**GULFEAGLE
SUPPLY**

GRADING & EROSION CONTROL
SITE / GRADING PLAN

C1.2 MVE PROJECT 61078
MVE DRAWING-GEC-SGP

MARCH 12, 2019
SHEET 2 OF 5

GRADING & EROSION CONTROL
SITE / GRADING PLAN

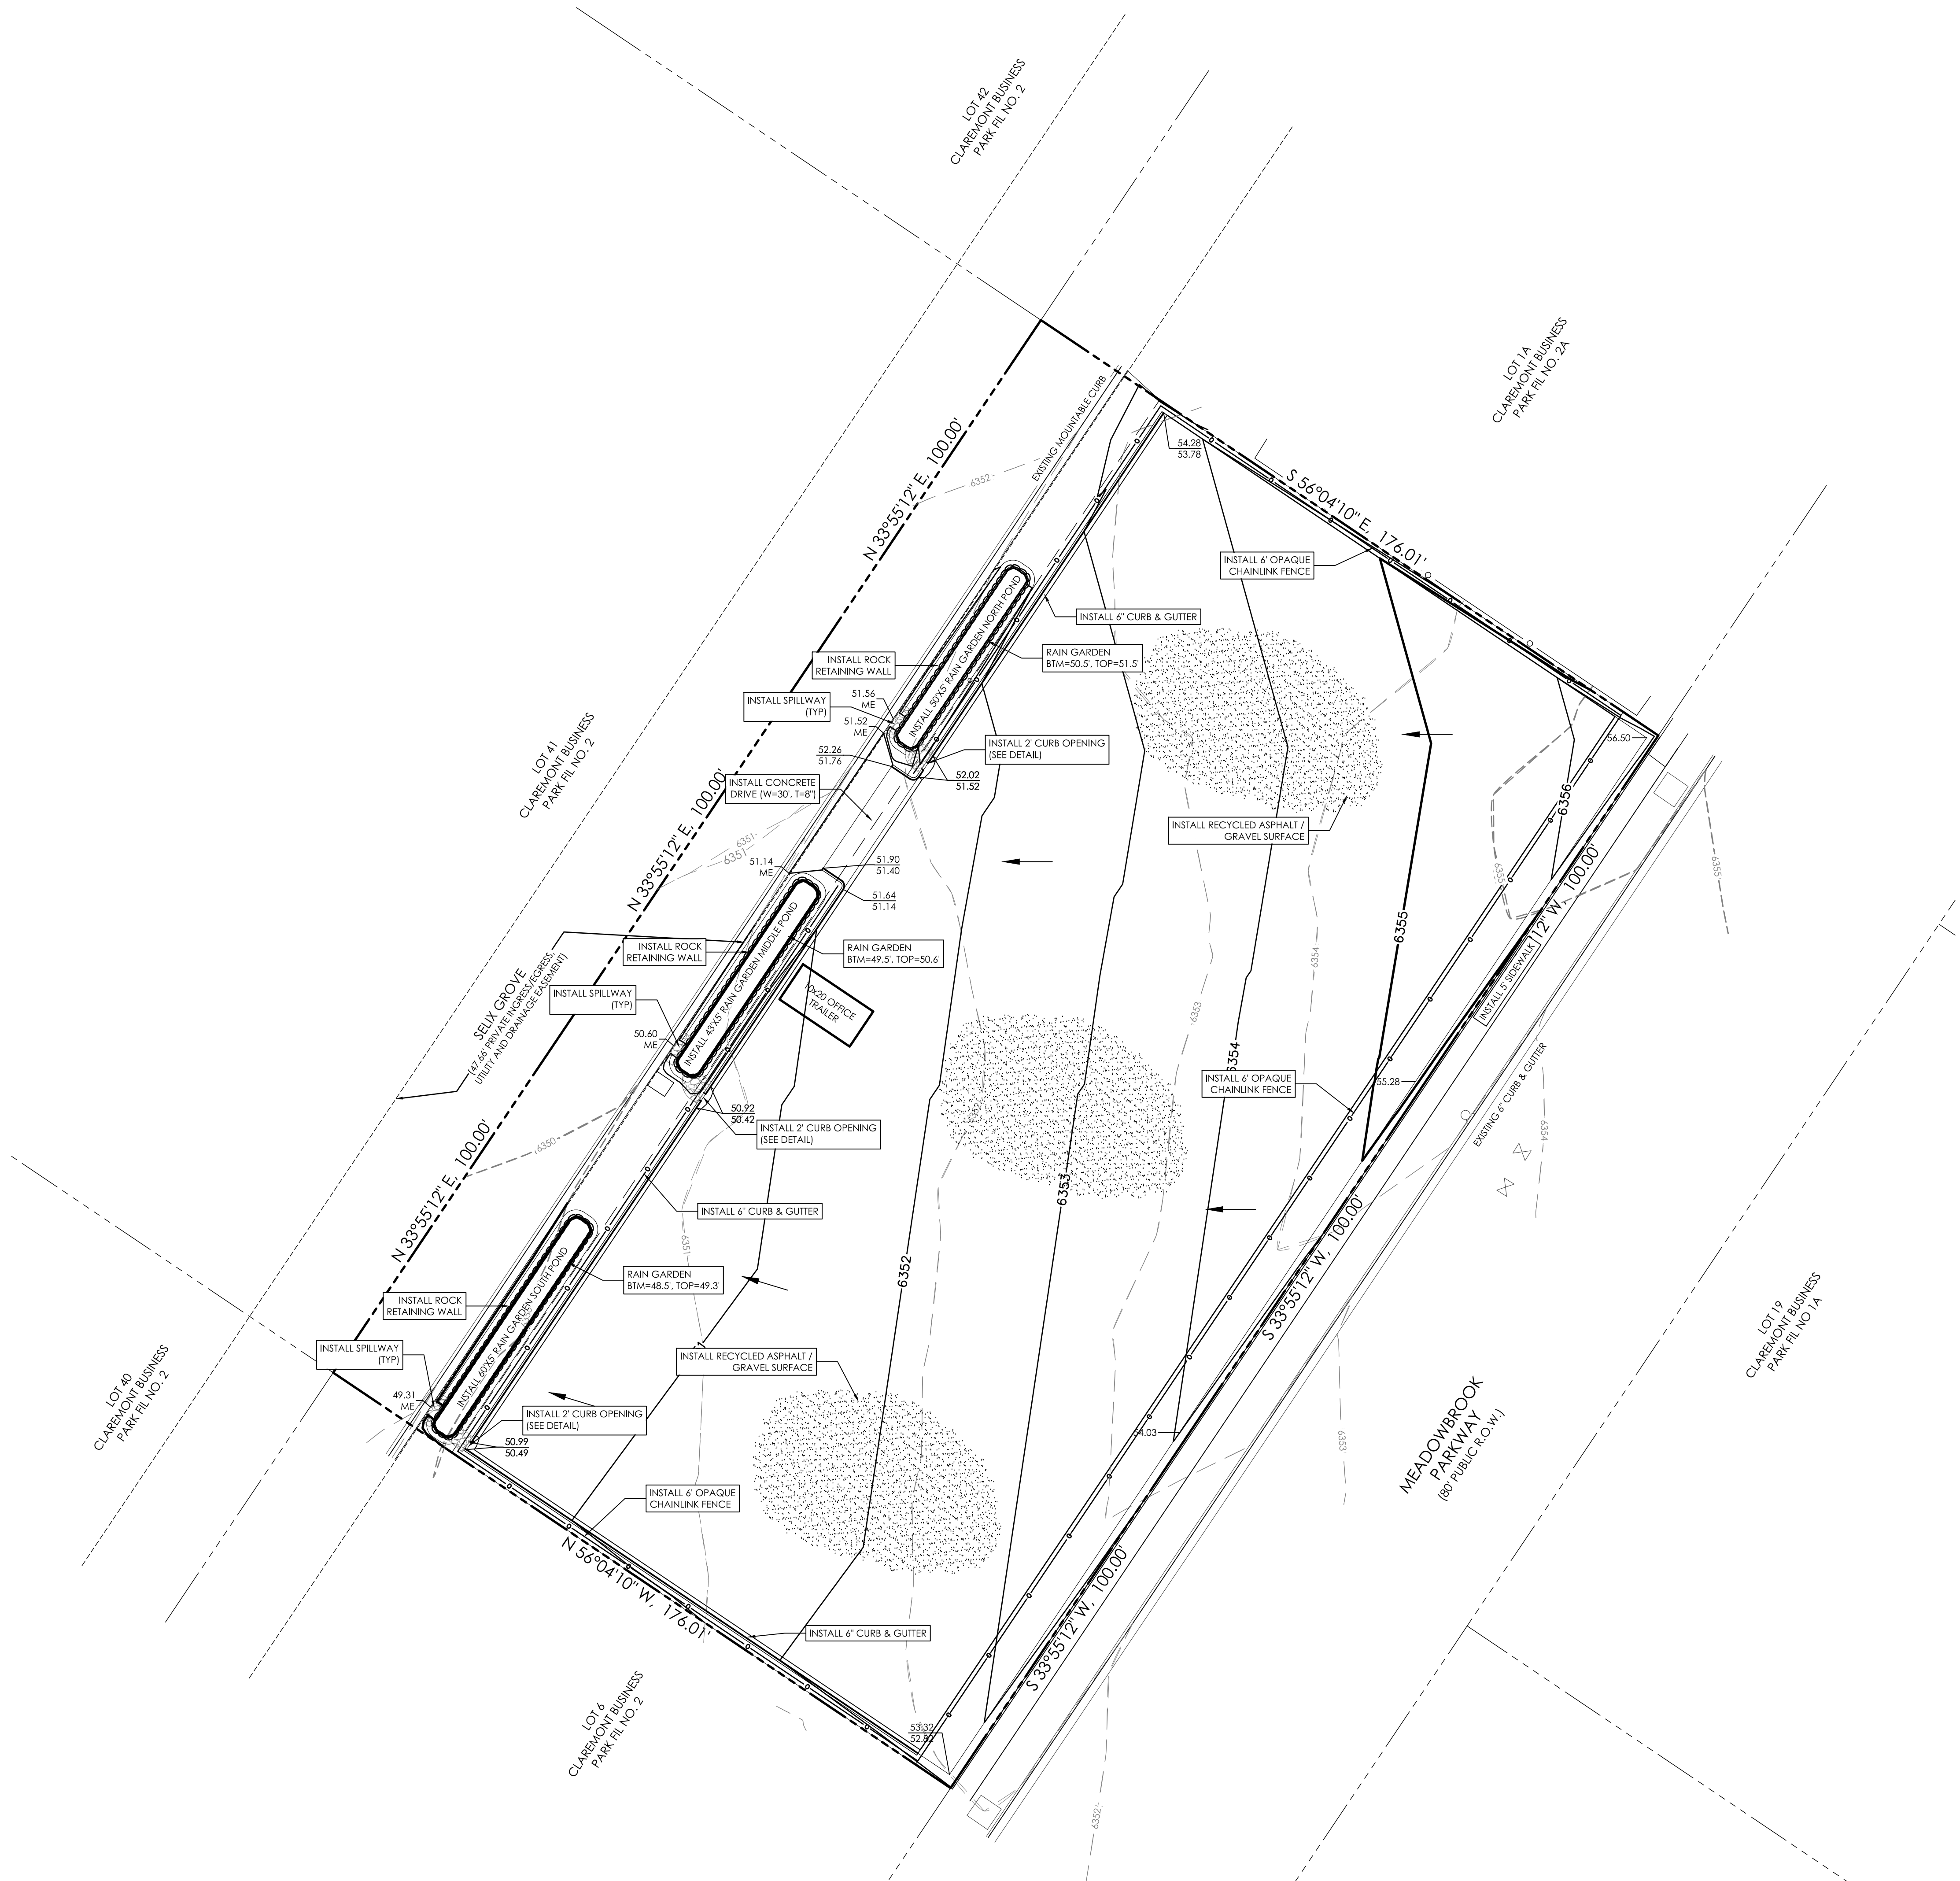
Per drainage calculations this water quality facility is a rain garden. Please label it as such or revise the calculations.

Please provide elevations of the bottom and top of the water quality facilities.

Please label this also as a Private Ingress and Egress Public Utility and Drainage Easement as shown on the plat.

The grading should be revised to create a local sump at these openings. With the curb openings designed at-grade a majority of the runoff may pass-by. Alternatively provide at-grade inlet calculations for the curb opening.

GRADING & EROSION CONTROL
NOTES AND DETAILS

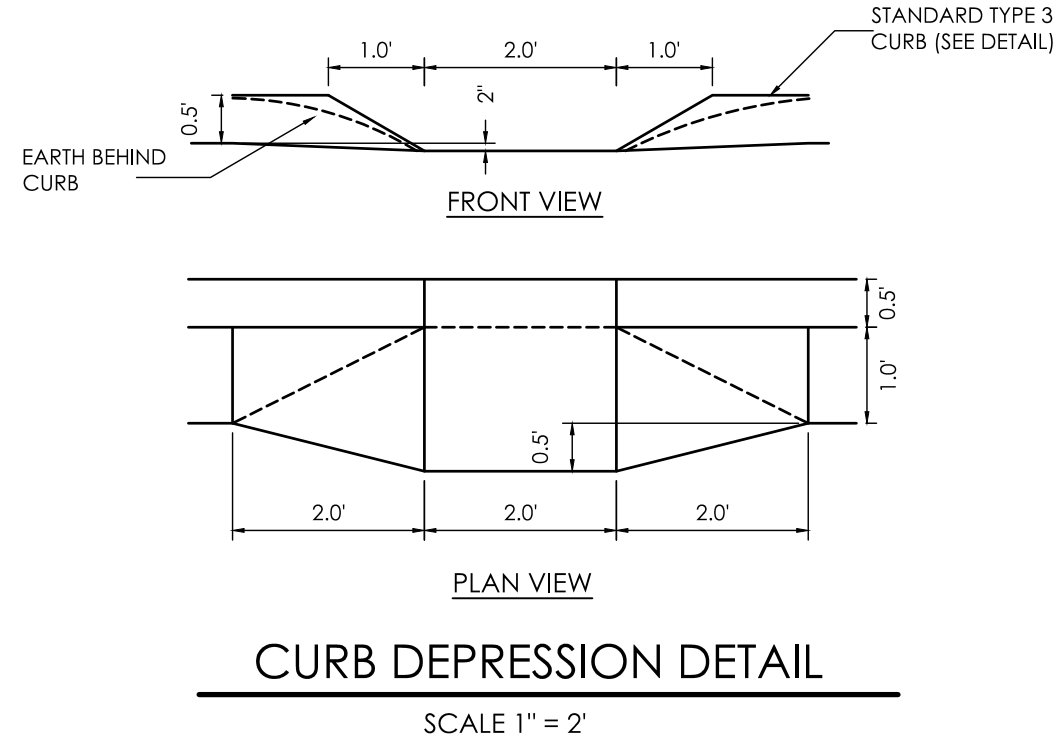
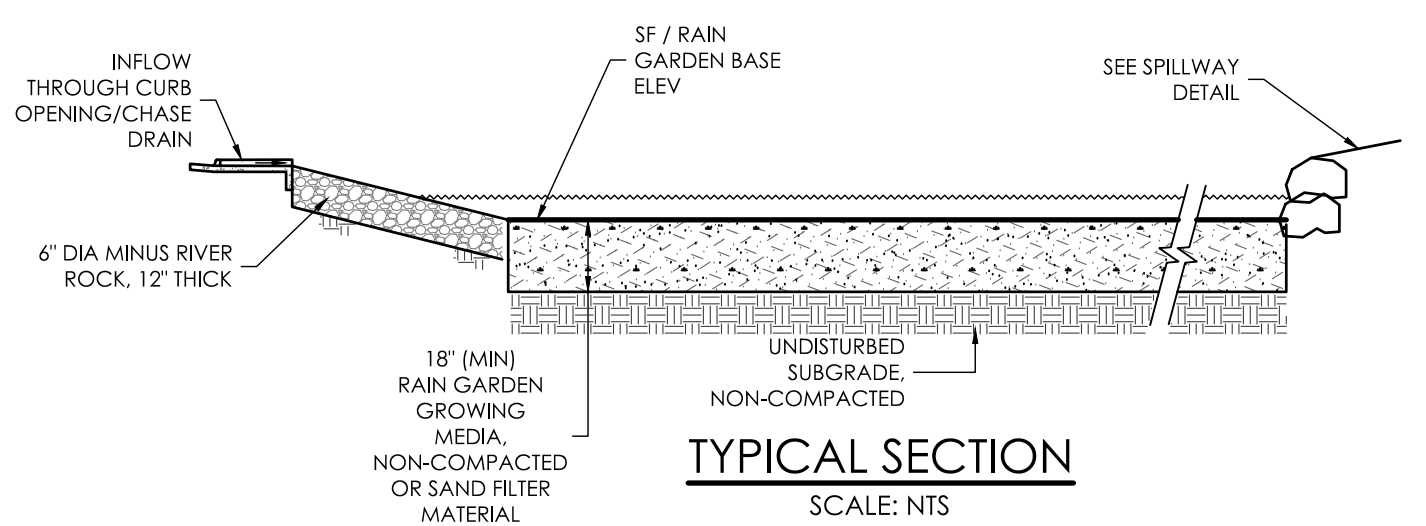
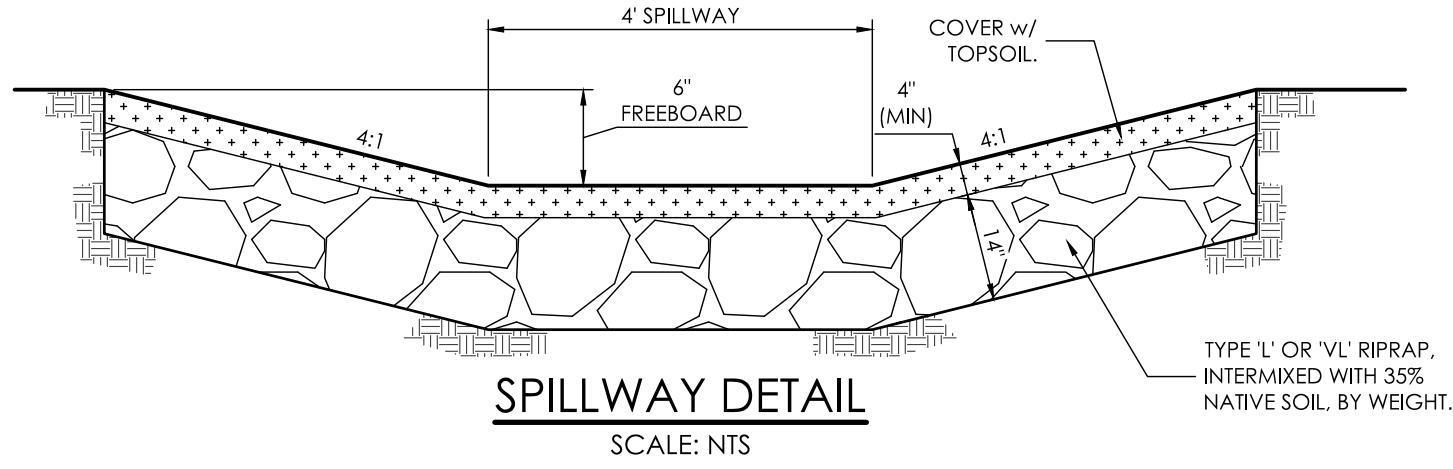
Add a note that states that on-site infiltration tests using a double-ring infiltrometer shall be performed where full infiltration sections are use per UDFCO criteria manual.

ROCK SOCK SECTION

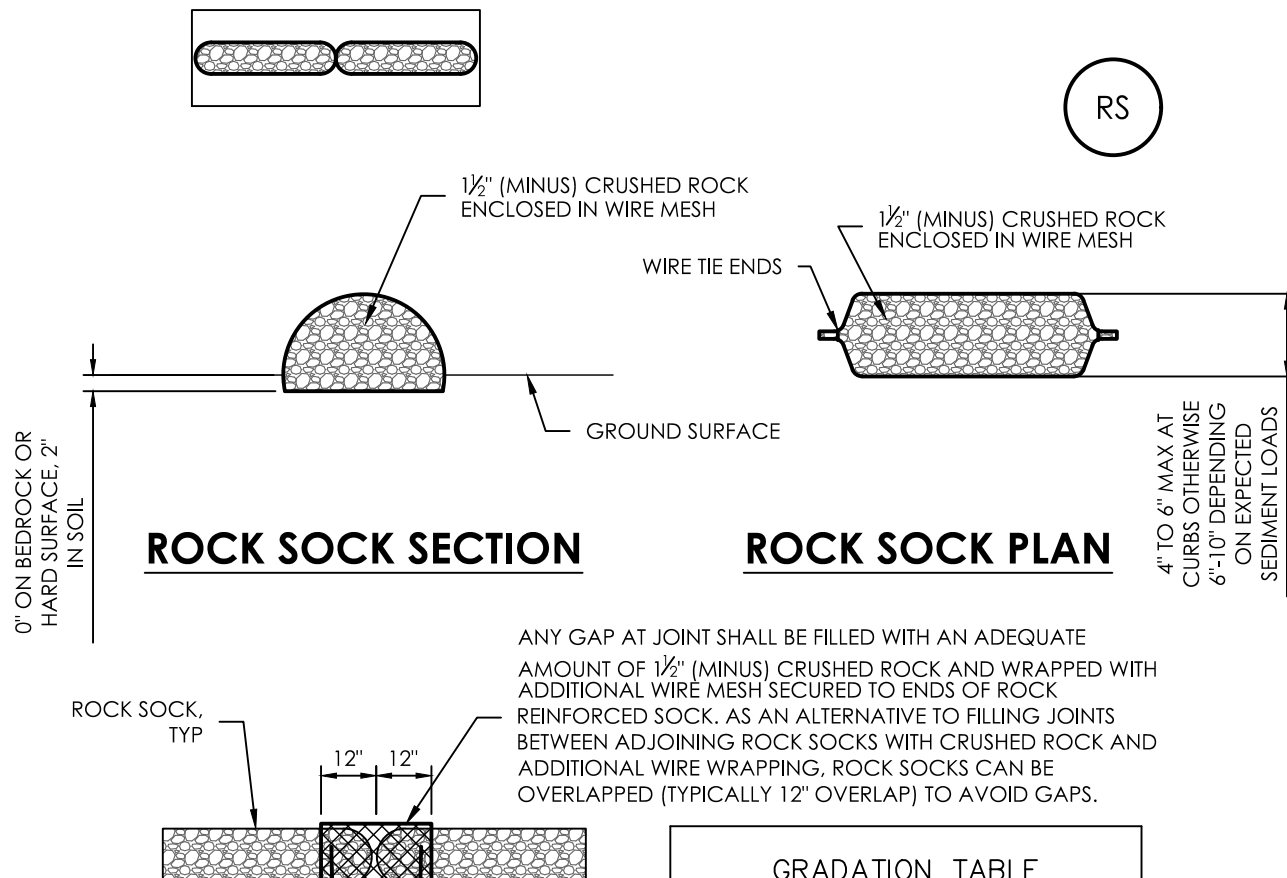
Please provide Rock Sock and Sediment Basin BMP details
